APFP Reference
Regulation 5(2)(a)

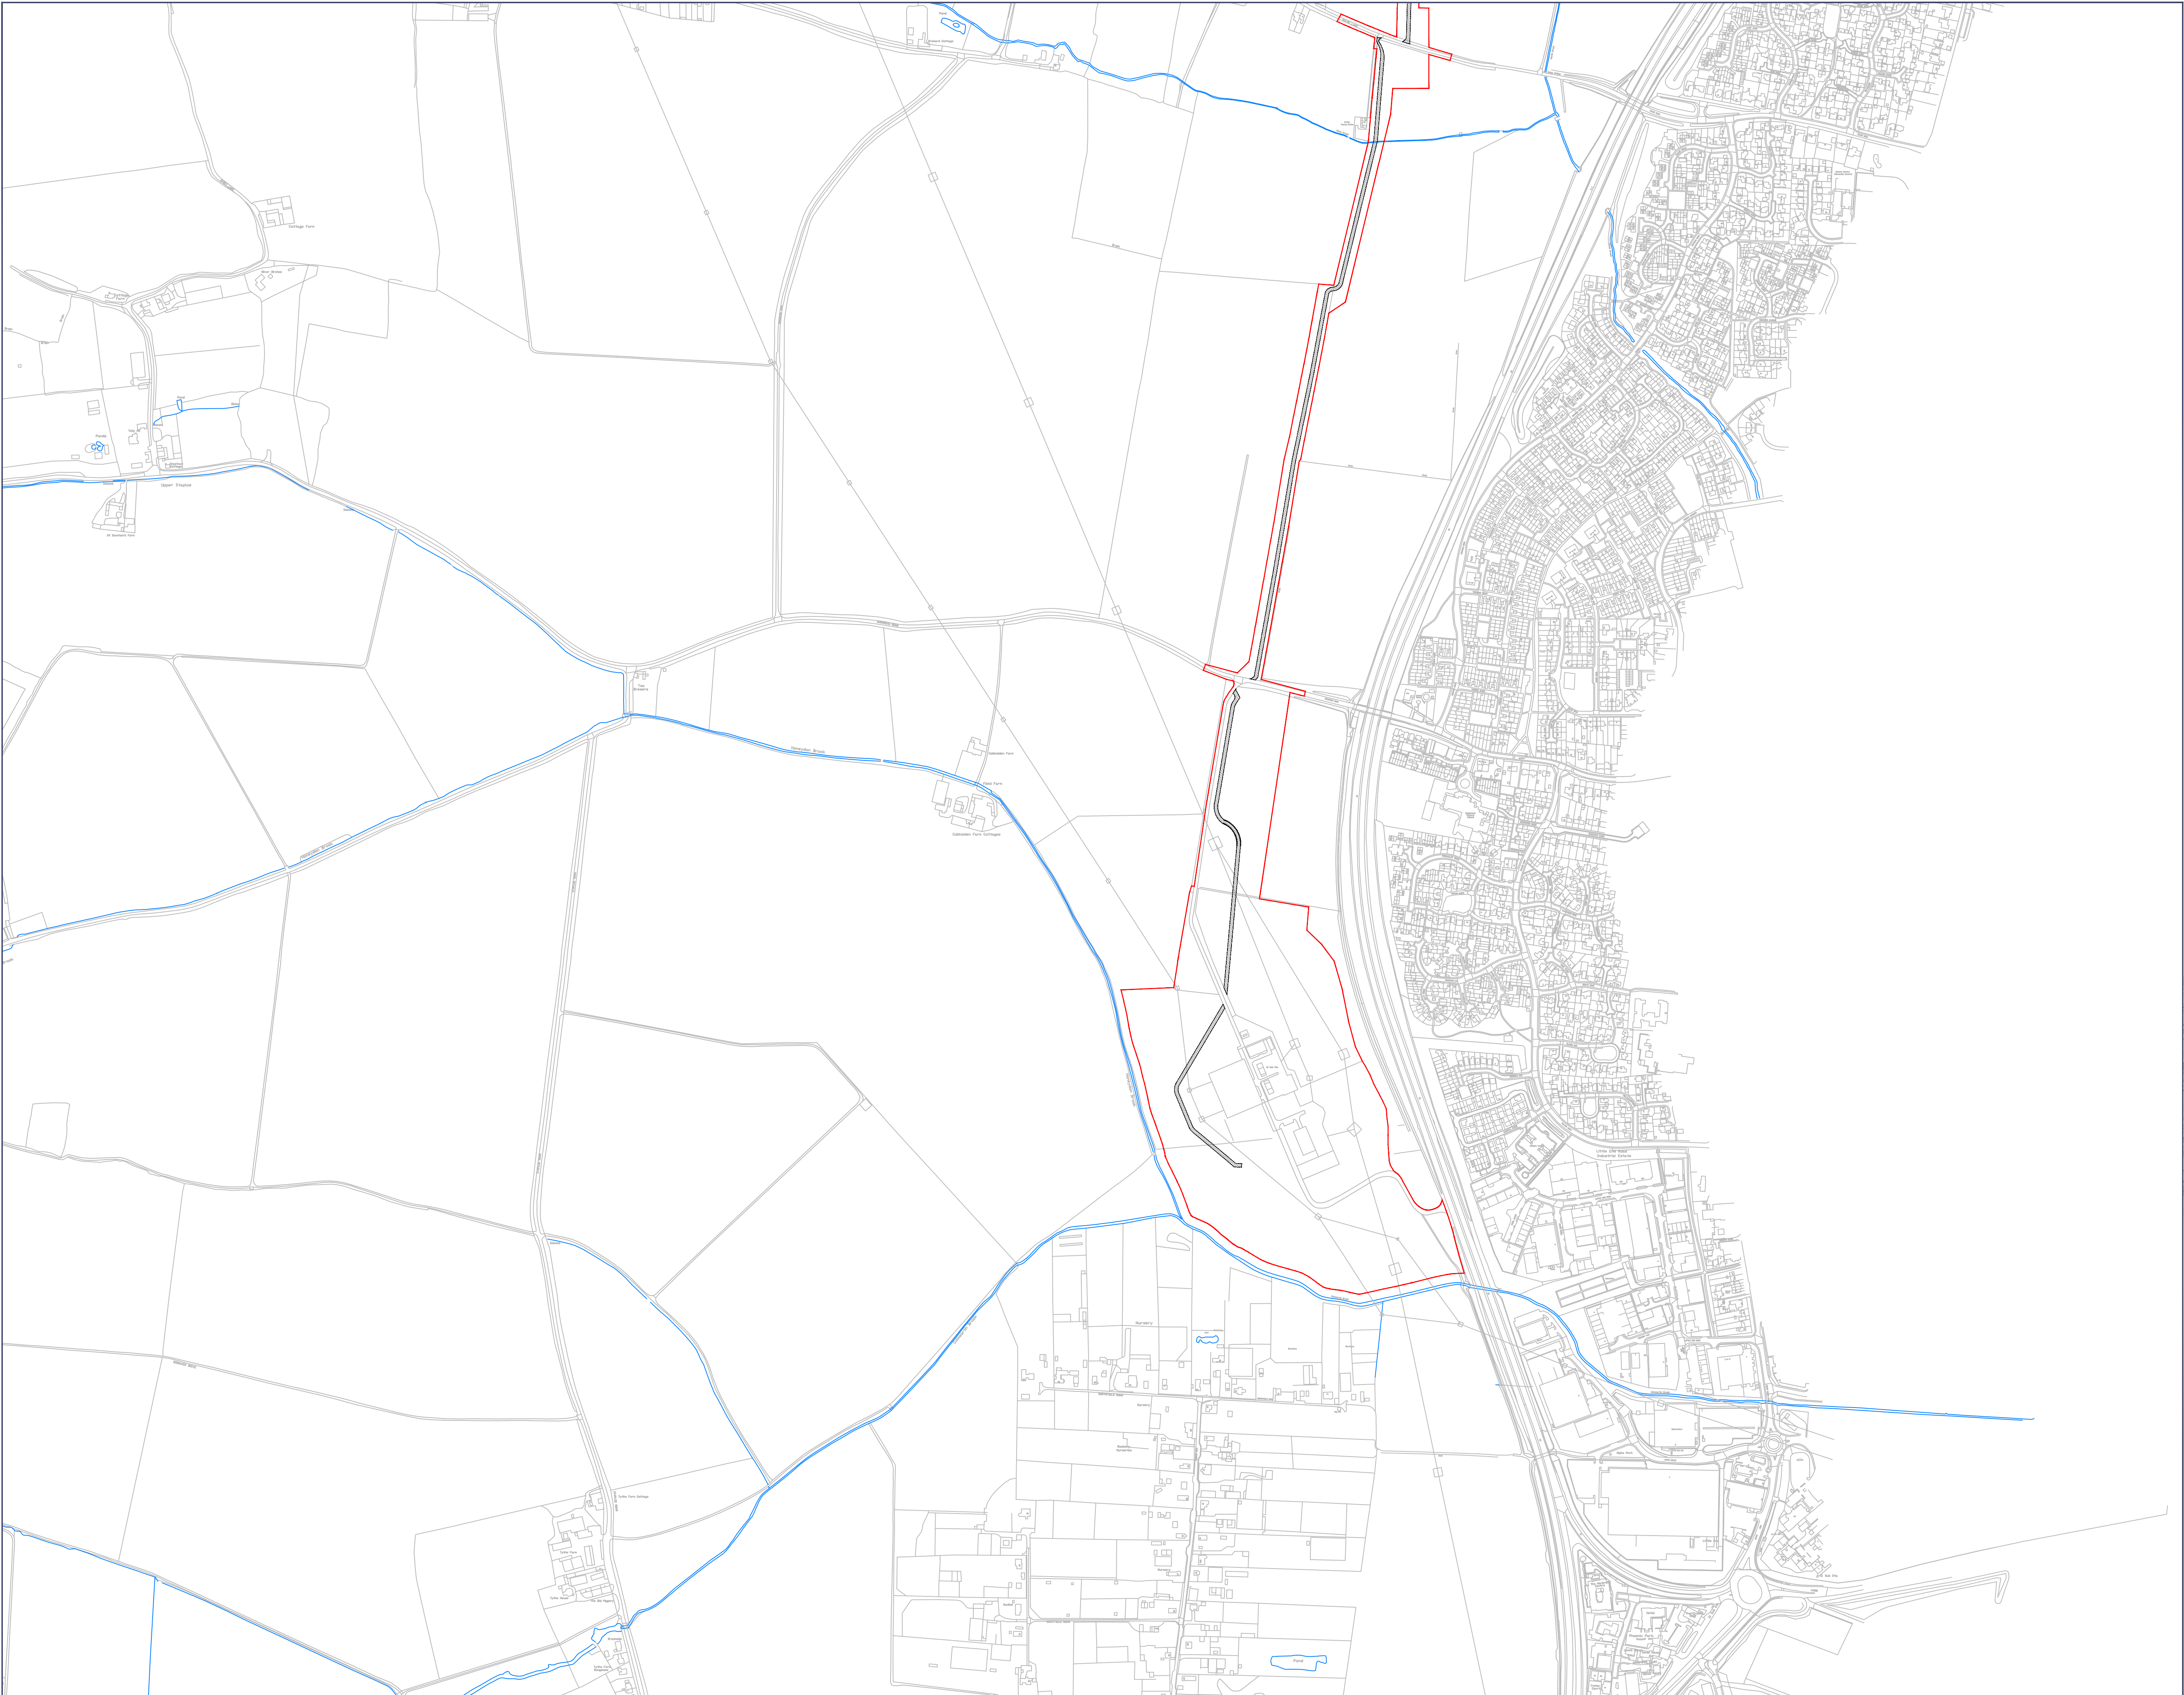
1. High Wood Solar Farm; this is in fact on a very busy B645 on a sharp bend so high volumes of traffic will be extremely dangerous and the path opposite is the only walking route for residents of Hail Weston.

2. Section 2 - Santra access (SA12) Spring Hill to Green End. This road is very narrow with tight blind bends.
3. SA06 access from Green End. This is already a dangerous crossroads at Kangeroo and has cars, bikes, motorbikes, horses and runners going through the junction regularly. The road from Kangeroo to the B645 is already showing as 'unsuitable for heavy vehicles' and two cars are not able to pass each other without slowing right down. Horse lorries have already been stopped from using this road. The plan is for the junction to be used for SA03, SA04, SA05 and SA06. This is a major accident hazard and the narrow roads would mean emergency vehicles could not get through.

4. Green End to Little Staughton. SA08, SA07, SA09 are all by homes. Green End goes through part of the village of Great Staughton next to homes.
5. It is unclear on Section 3 where the traffic is planned. It says turning right but if it is a right turn, how is the traffic getting to Manor Farm.

6. Section 4 Moor Road. This is a very narrow road with dangerous blind bends and is totally unsuitable for the volume of heavy goods vehicles planned.
